18 April 2011

Section 75W Modification to MP 09_0044 – Minor Design Changes to Façade and Terrace

Park Hyatt Hotel, The Rocks

JOB NO.	DRAWING NUMBER	REV
AX002514	A-301	F

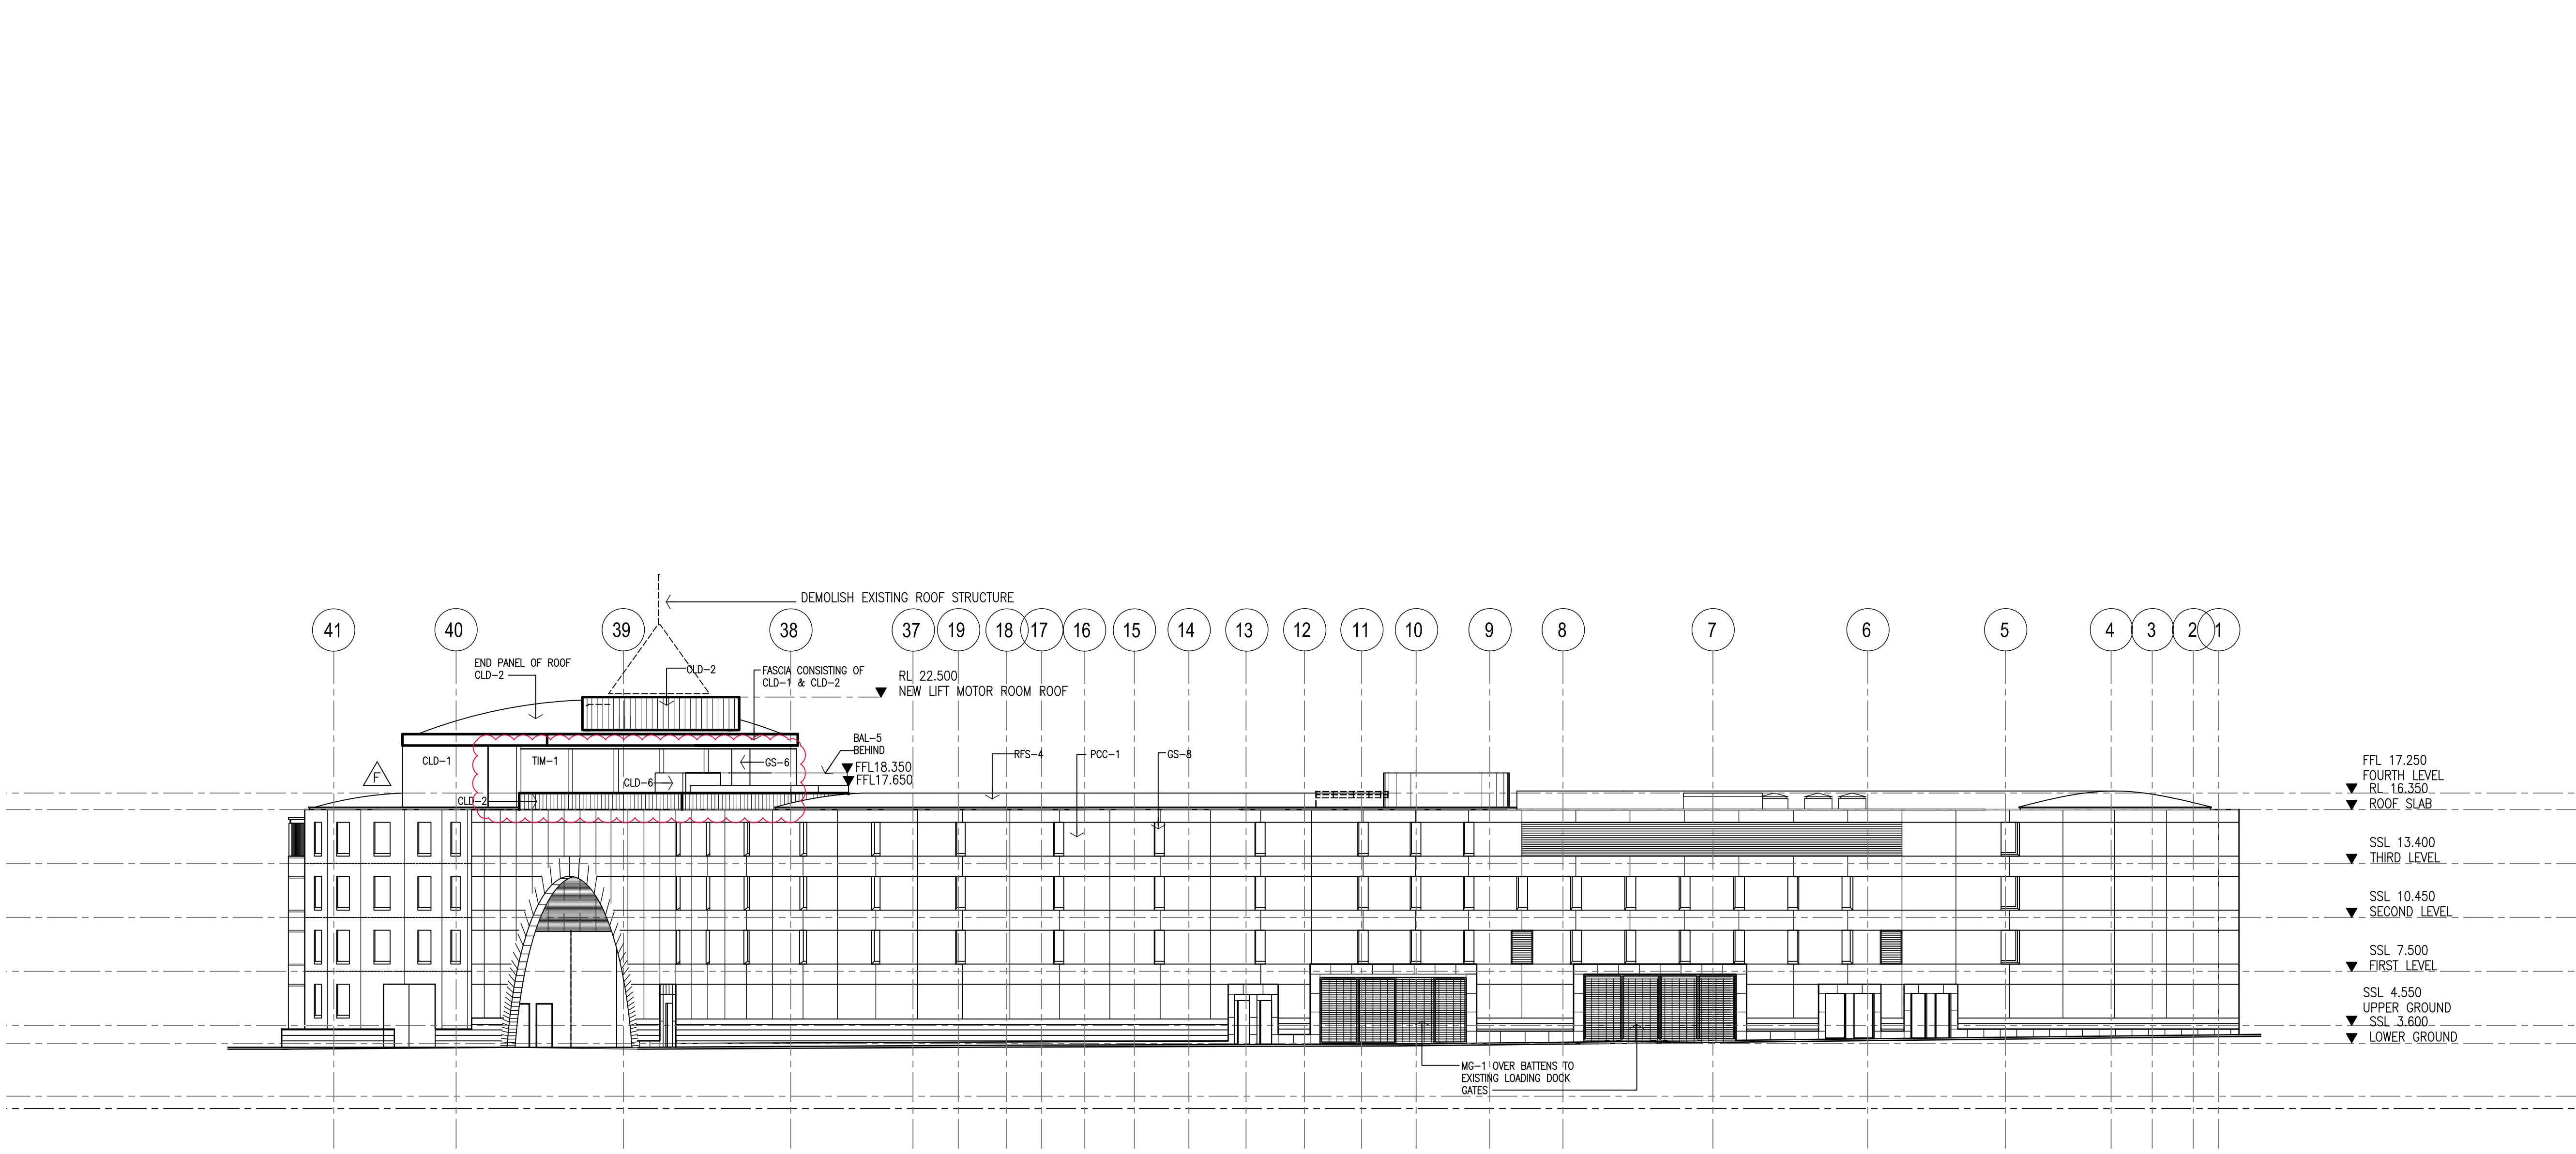
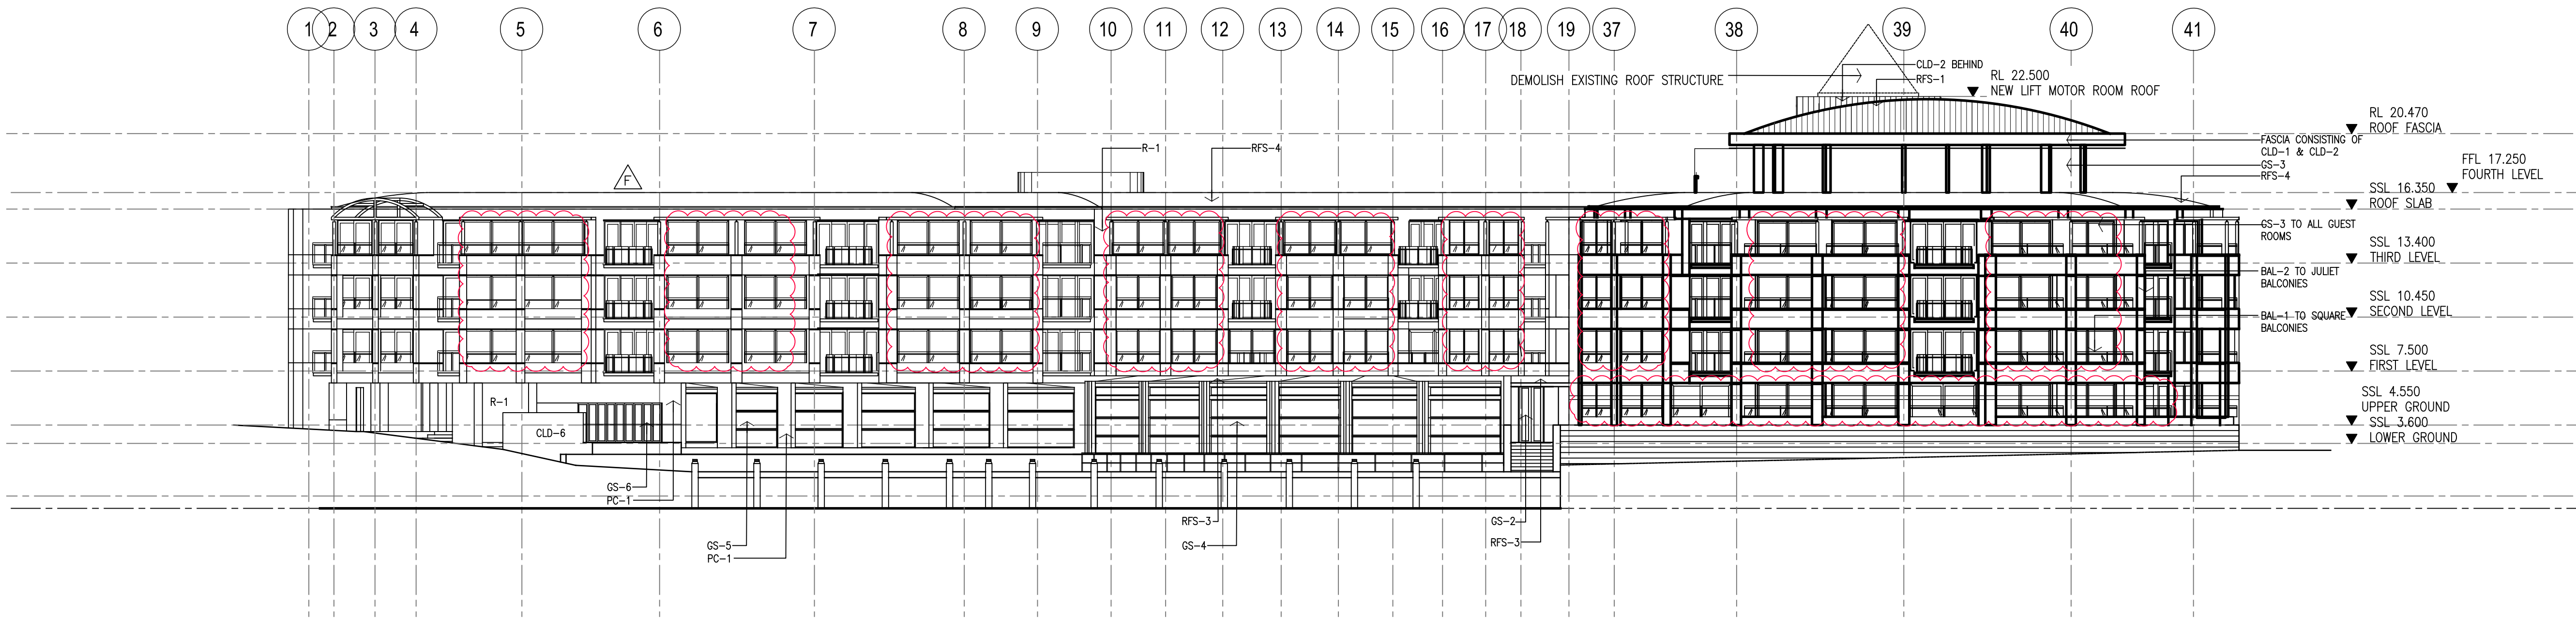
- Change to pool terrace design by reducing the extent of the pool terrace by some 1.2m to 2.5m at its western end level. This results in a reconfiguration of the layout of the western end of the pool terrace including relocation of the Jacuzzi and deletion of Stair 5.
- The raising of the finished floor level of the pool terrace level in the north-eastern area, east of the pool by 0.45m (from FFL 16.80 to FFL 17.25) to provide a consistent floor level to the approved FFL level of 17.25 over the majority of the pool terrace level, as illustrated in the diagram below.

- Minor landscape design amendments that reflect the alteration to the reduced pool terrace area; the conversion of a planter area in the north eastern corner of the pool terrace to a timber platform for roof maintenance purposes; and the removal of strip landscaping adjacent to the day spa.
- Provision of fixed window to the existing balcony apertures of rooms on the northern elevation and deletion of balcony railings.
- Change from 4 panel glazed door system to 2 panel glazed door system of the square balconies as shown on the southern, northern and western elevations.
- Reduction of terracotta screening on the Northern Elevation, which will increase the visibility of the glazing elements behind.

- *Reduction of Pool Terrace extent, reduction and relocation of Jacuzzi*
- *Increased extent of Planters on western and southern terrace edge*
- *4 Panel glazed door system of Box Balconies to 2 Panels*
- *Demolition of North facing Parkview rooms balustrades/balconies, installation of new window in existing aperture.*

Drawing  
SKL-102\_REV C

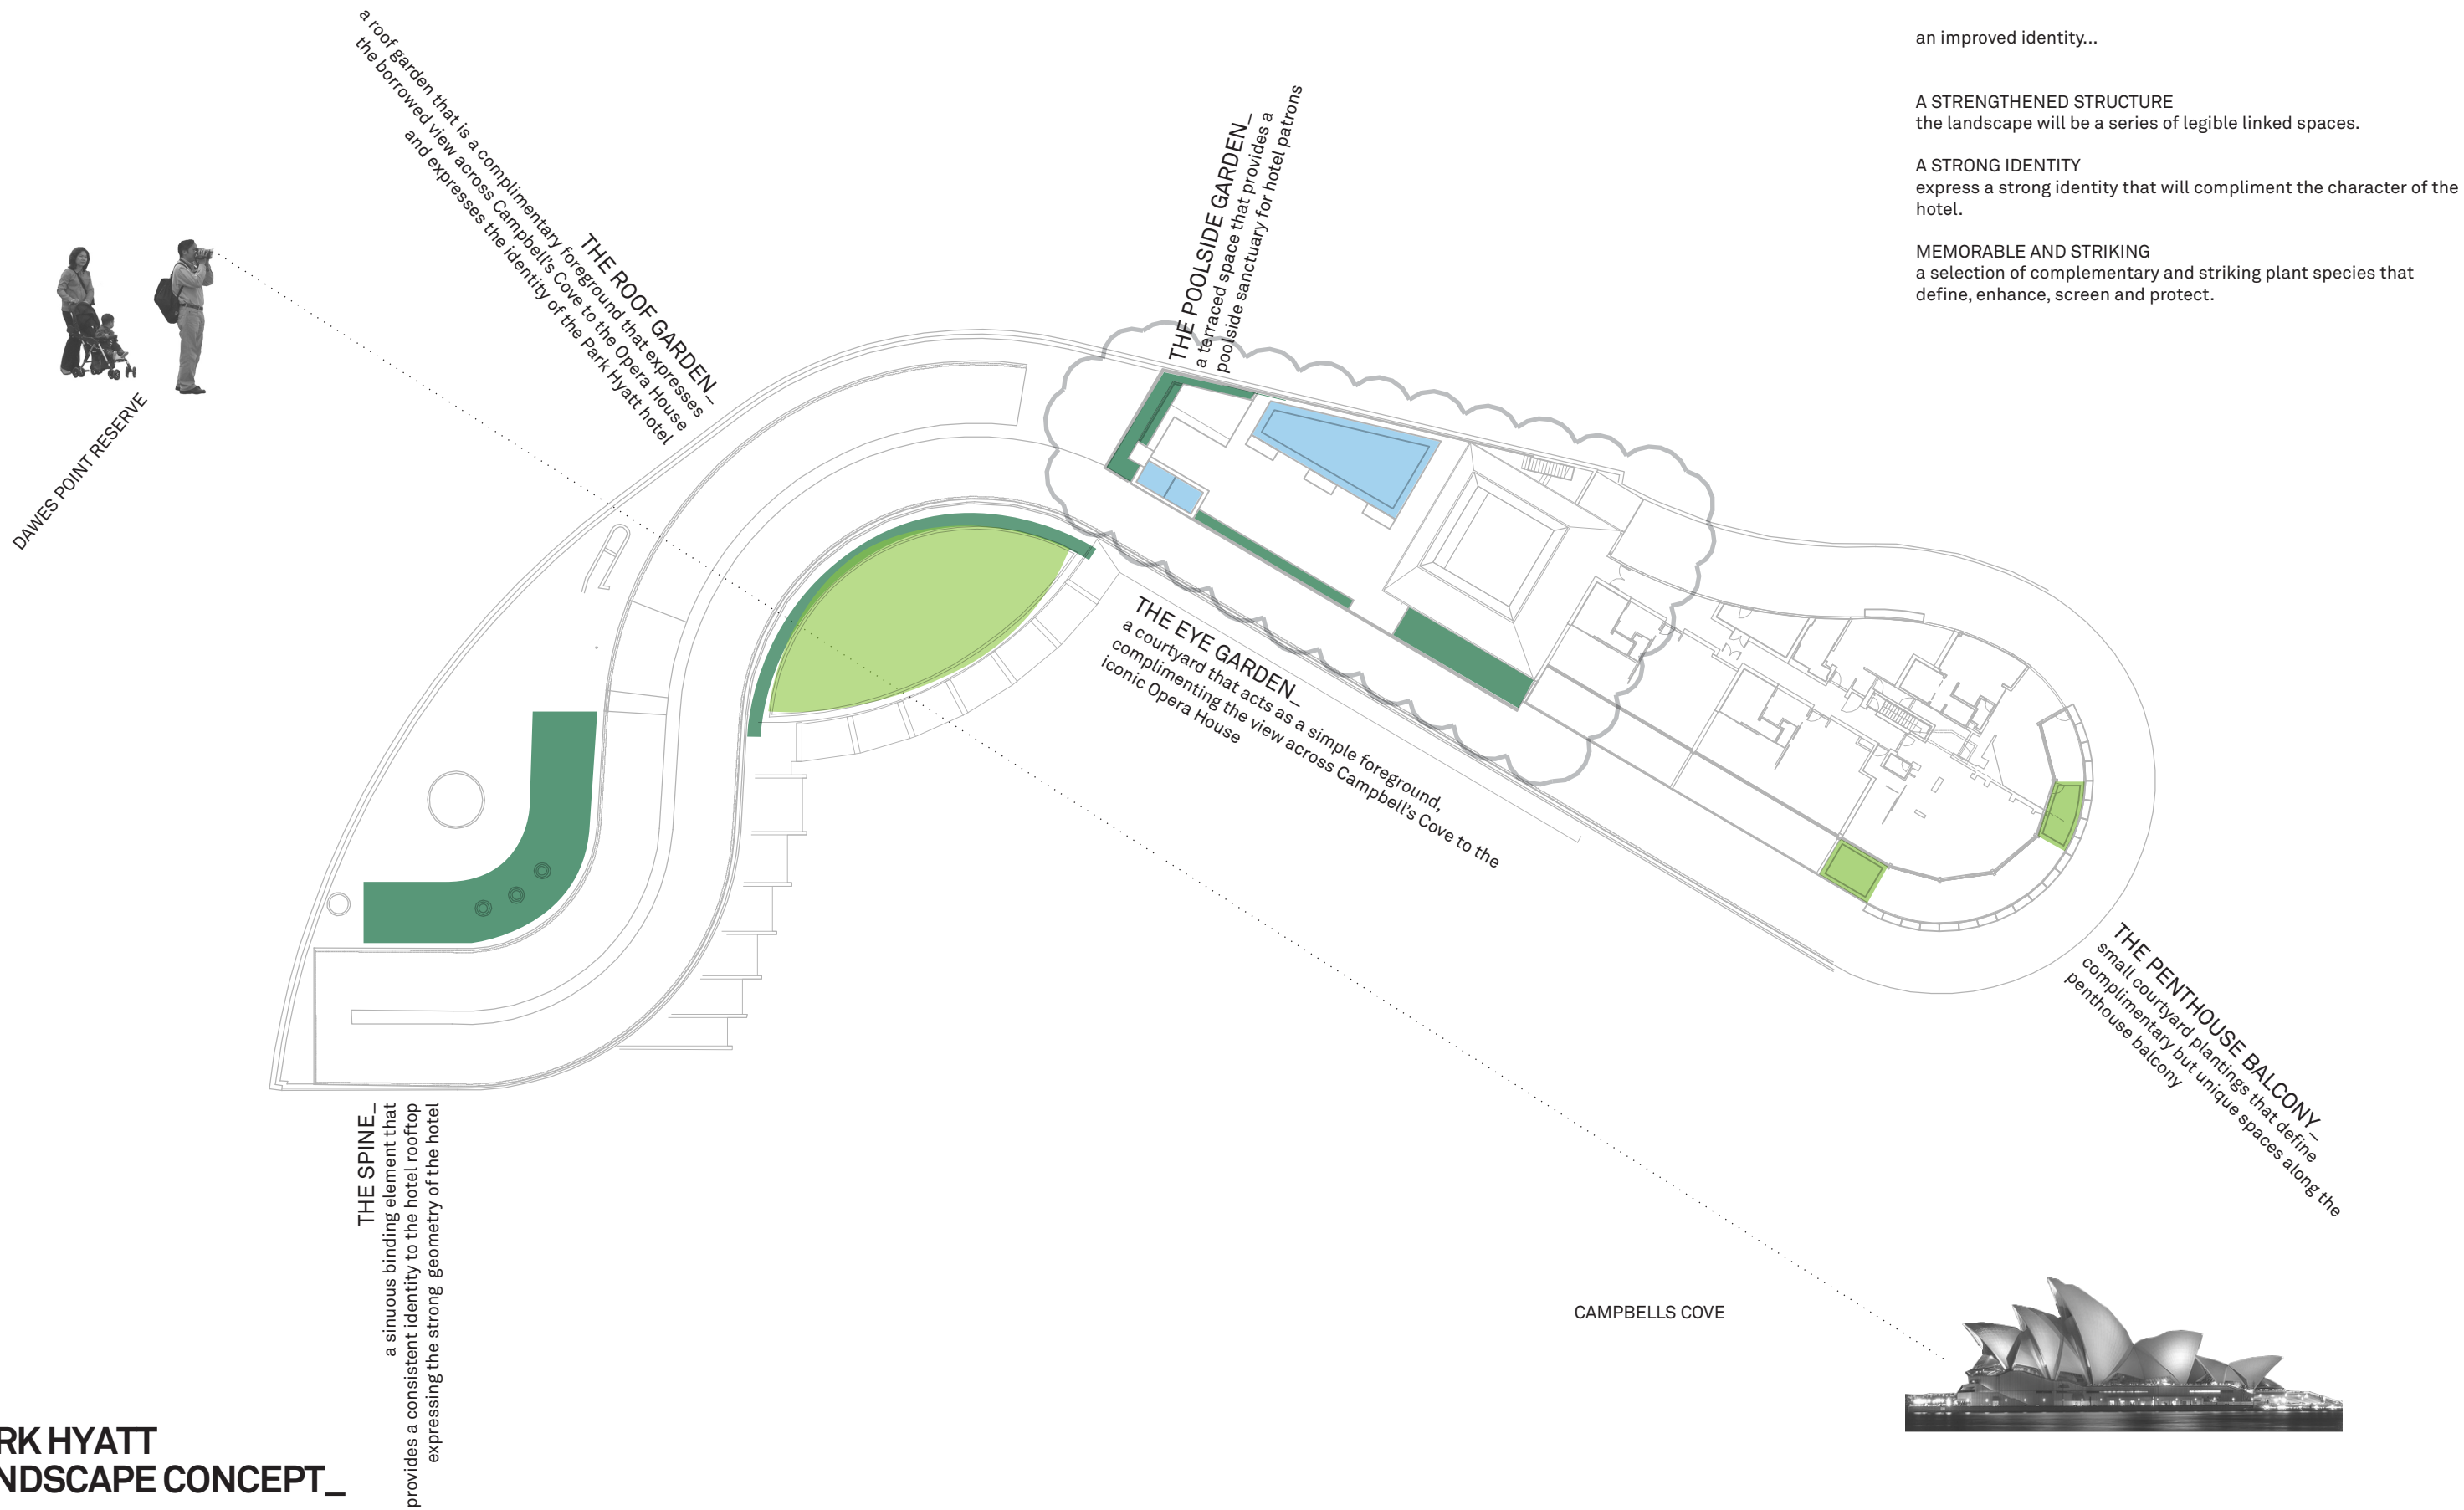
- Landscaping that reflects the revised western end of the pool terrace, which includes a wider landscape edge to the west and an additional landscape area along the southern edge of the pool terrace;
- The removal of the landscape planter previously proposed at the north-eastern corner of the pool terrace; and
- Removal of the Level 2 spa room planter behind the proposed screen along the northern edge due to the inability to achieve sufficient soil depth to sustain growth.
